Consultation Response from KC Lead Local Flood Authority
2019/91333 Cummins Turbo Technology, St Andrew's Road, Huddersfield, HD1 6RA
Erection of single storey temporary office accommodation including associated welfare facilities and infrastructure

Further Information Required

MODELLED 1 IN 100 + 10% CC FLOOD EXTENT

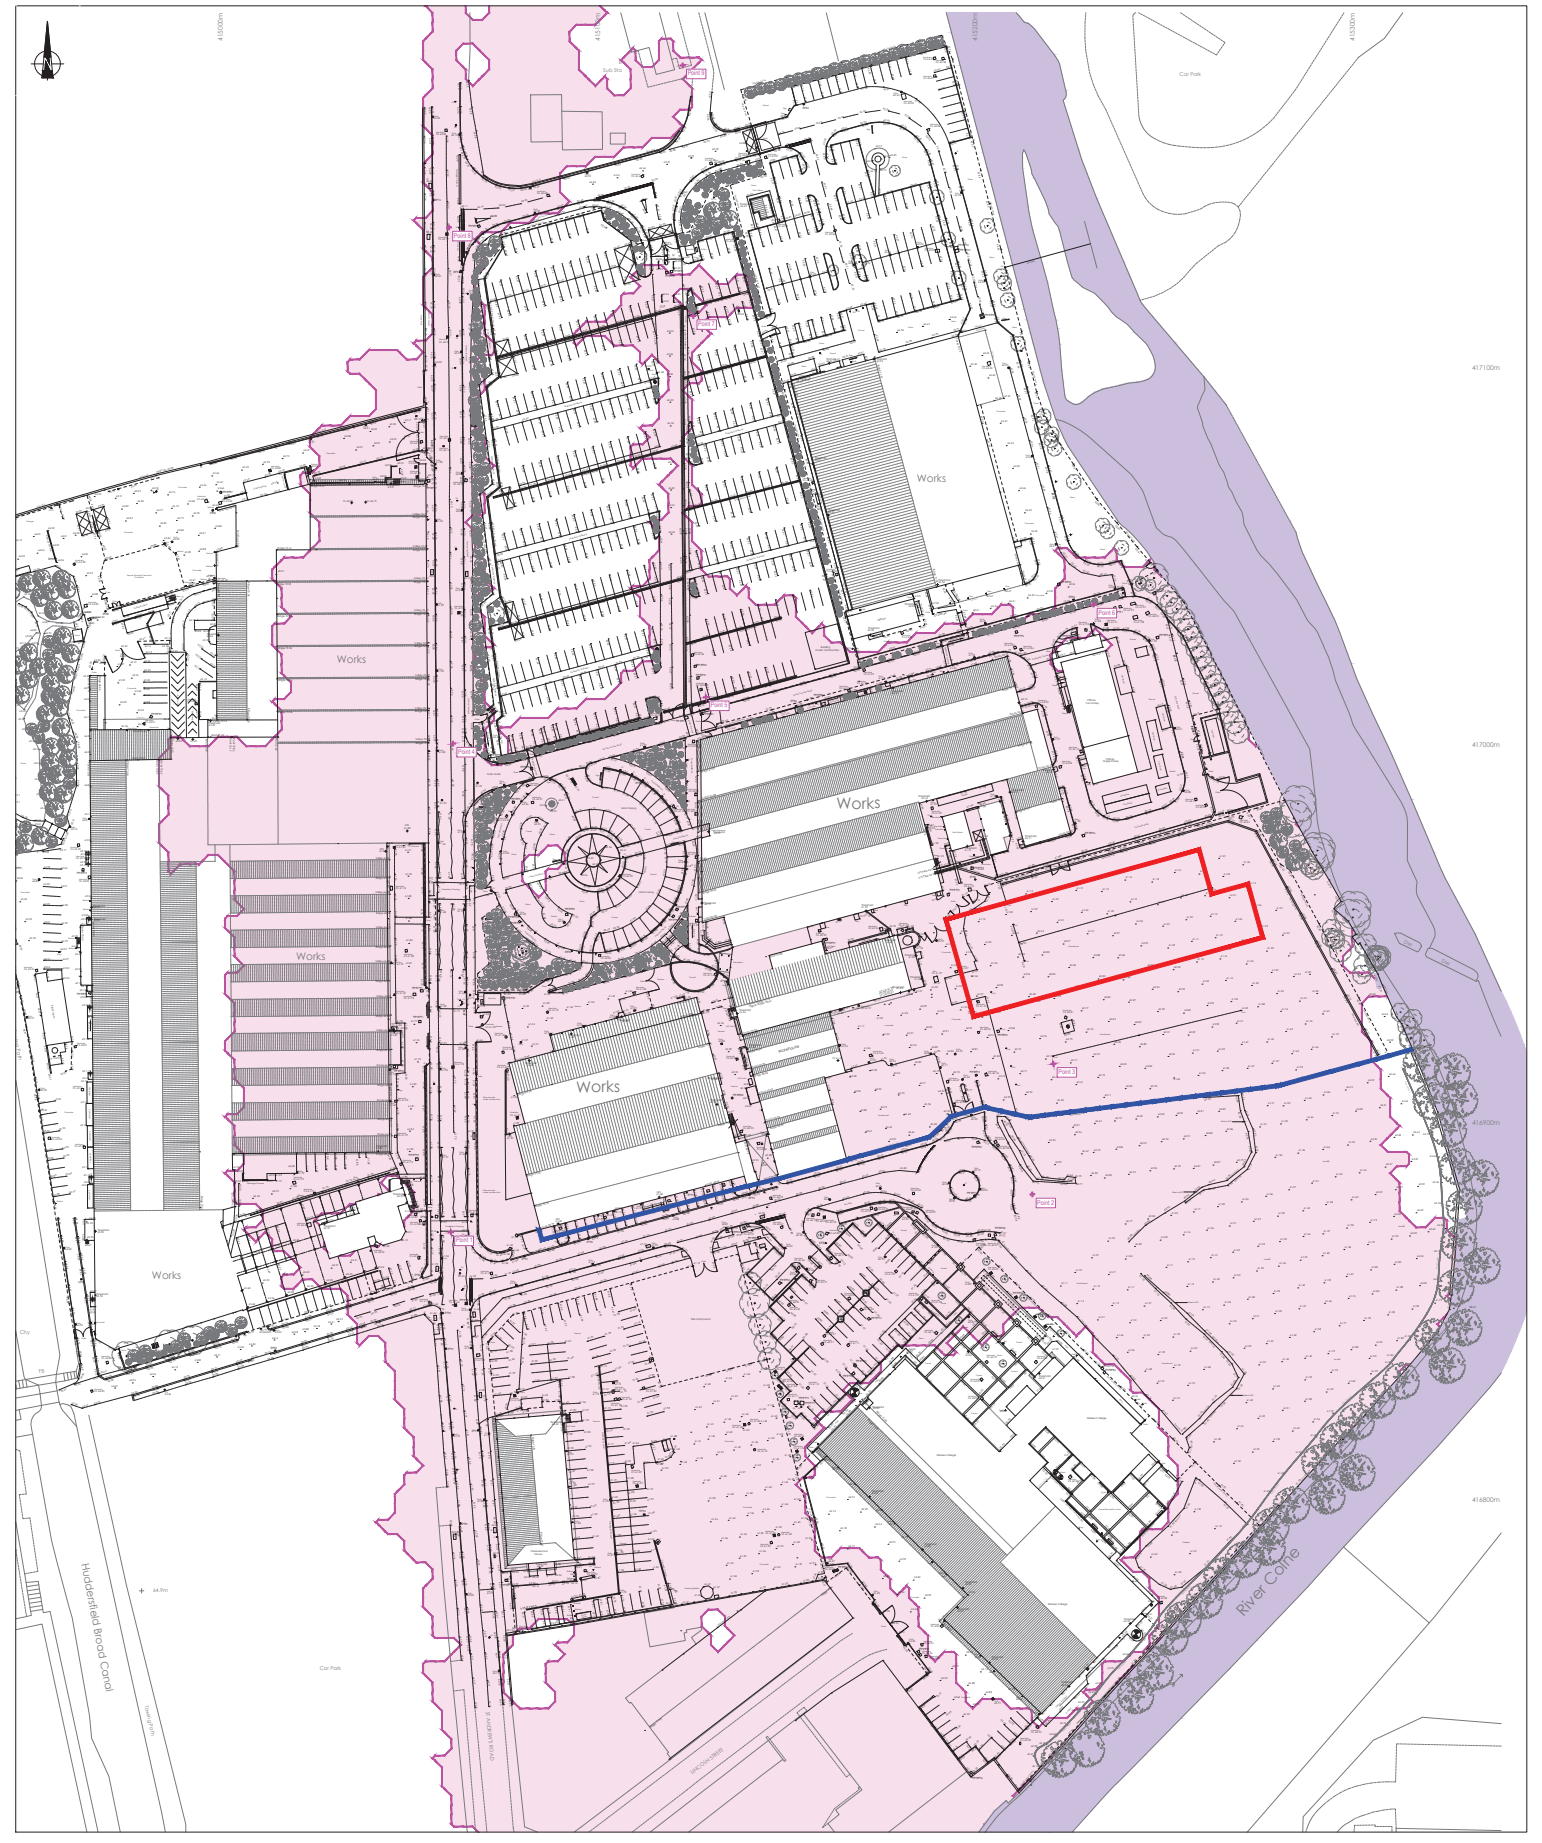
The location of the proposed temporary offices is entirely in the Environment Agency's Flood Zone 3. This zone has an annual probability of flooding of 1:100 or greater.

We acknowledge that the site already has a similar development adjacent to the one currently proposed. If a Flood Risk Assessment has been carried on the previous office building, an amalgamation of this could be accepted.

The Flood Risk Assessment requires more information. Our main concern is the lack of a Flood Management Evacuation plan. This should include,

- The plan should include the detail of provisions of flood warning systems.
- Arrangements for emergency access to the site.
- Egress from the site to a place of safety.
- Details of how residents and staff will be informed of the procedures to follow in the event of receiving a flood warning or actual flood event occurring.
- The evacuation plans shall be implemented in accordance with the approved details prior to work commencing on site, prior to the occupation of the development and thereafter retained throughout the lifetime of the development.
